**From:** Brenda Larsen  
**Sent:** Wednesday, January 30, 2013 9:45 AM  
**To:** Jeff Watson  
**Cc:** paulingram@johnlscott.com  
**Subject:** RE: BL-12-00038 State Parks

Re: State Parks (BL-12-00038)

BOUNDARY LINE ADJUSTMENT
 PREPARED FOR
 WA STATE PARKS
 LOCATED IN PORTIONS OF SECTION 13 AND 14,
 TOWNSHIP 19 NORTH, RANGE 16 EAST, W.M.
 KITTITAS COUNTY WASHINGTON

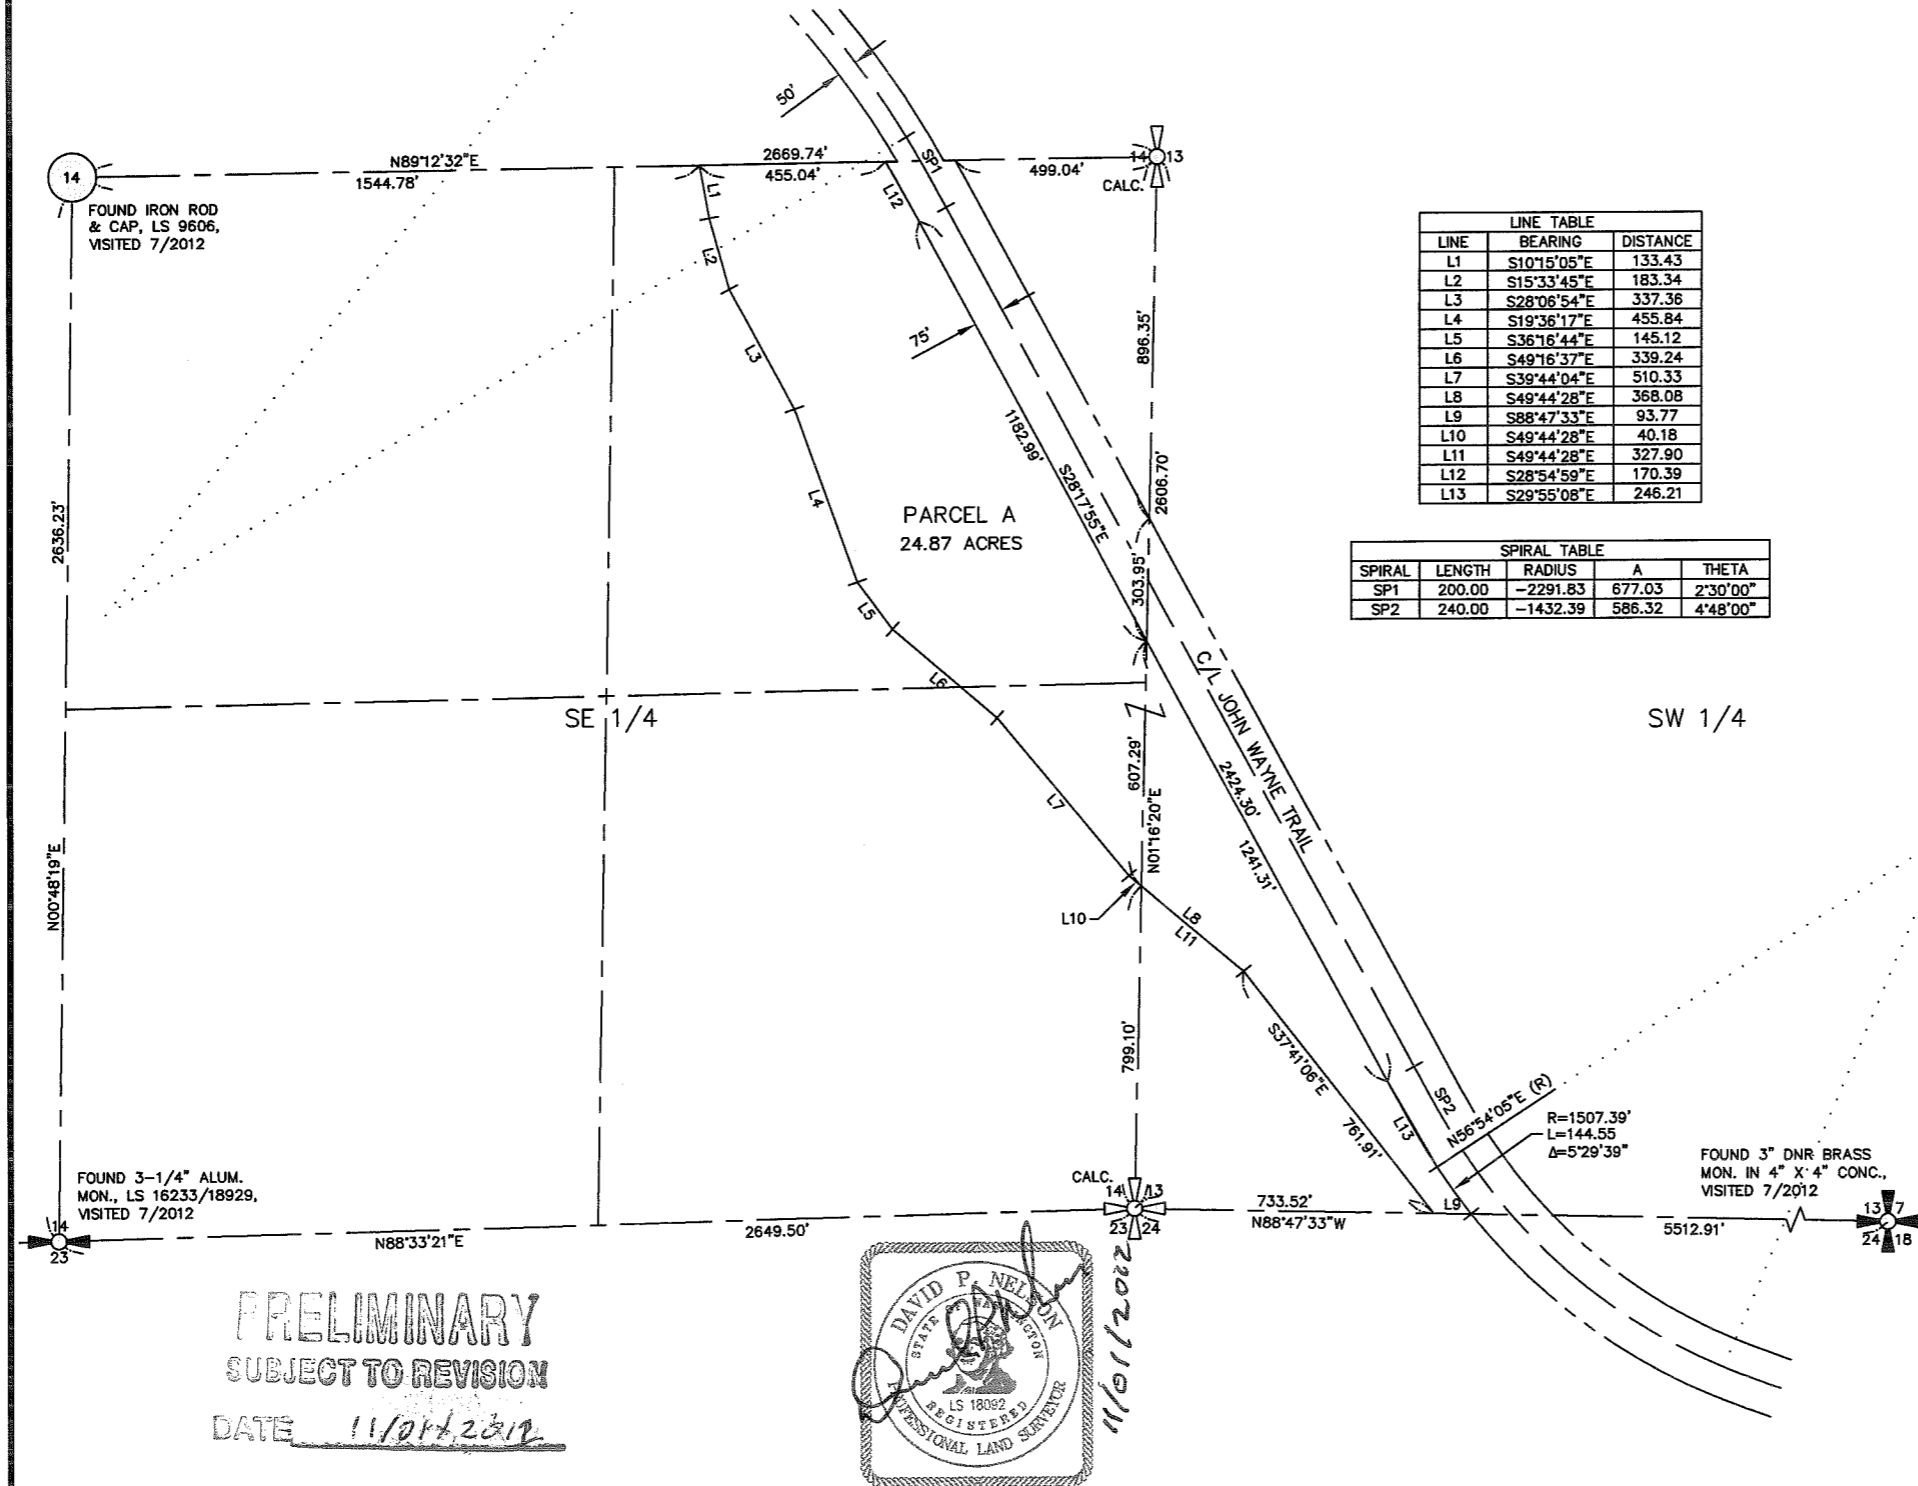
- Any new roads that are created are to comply with Kittitas County Road Standards and the International Fire Code.
- Ensure that boundary line adjustments do not infringe upon existing structures, to include propane tanks, etc.
- All future development must comply with the International Fire Code.
